From: Sarah Burrow <Sarah.Burrow@arun.gov.uk>
Sent: 28 July 2021 16:07
To: Planning.Responses <Planning.Responses@arun.gov.uk>
Subject: RE: Planning Consultation on: BN/92/21/DOC

Engineers Comments Regarding Surface Water Drainage

Application No: BN/92/21/DOC
Registered: 2nd July 2021
Site Address: 8 Collins Close Eastergate PO20 3JT
Description of Works: Approval of details reserved by condition imposed under BN/16/21/HH relating to condition 3-surface water drainage.

Drawing Title **Surface Water Drainage**

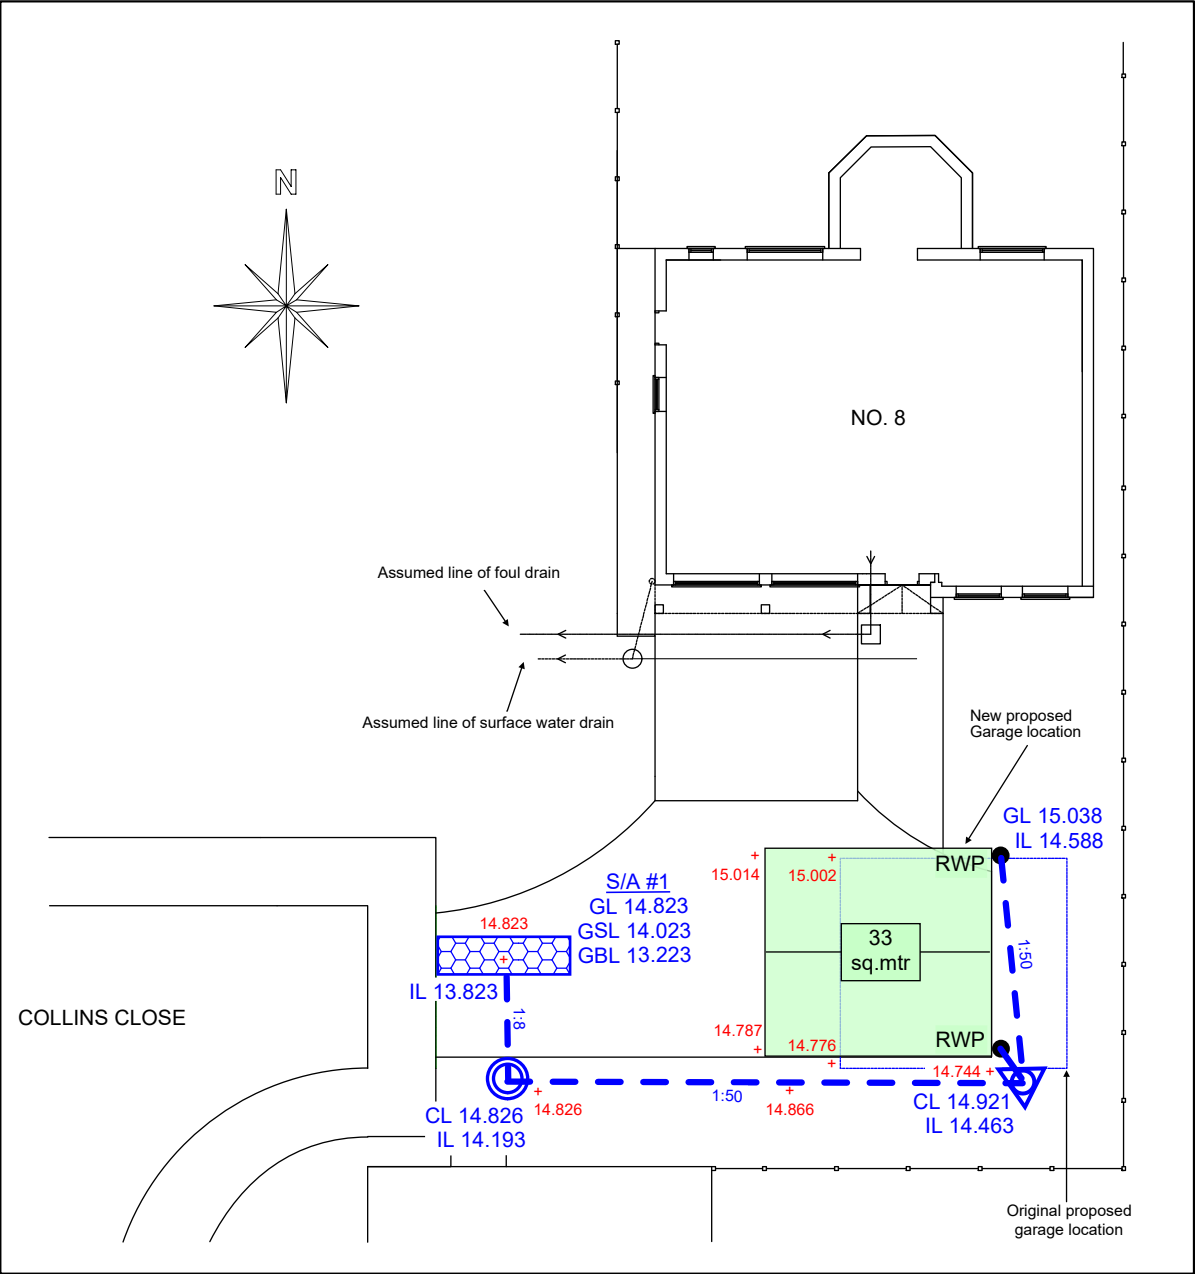
I am satisfied that the proposed surface water drainage design meets our requirements. I was concerned that the soakaway may be too close to the highway, however Andy Howick from WSCC has confirmed that due to the scale of the proposal they would not object in this instance. Therefore it is recommended that Condition 3 is discharged.

Please construct surface water drainage in accordance with the following plans:

- Surface Water Drainage MSG-BN/16/21-Rev02
- Constructional Details MSG-BN/16/21-Rev02
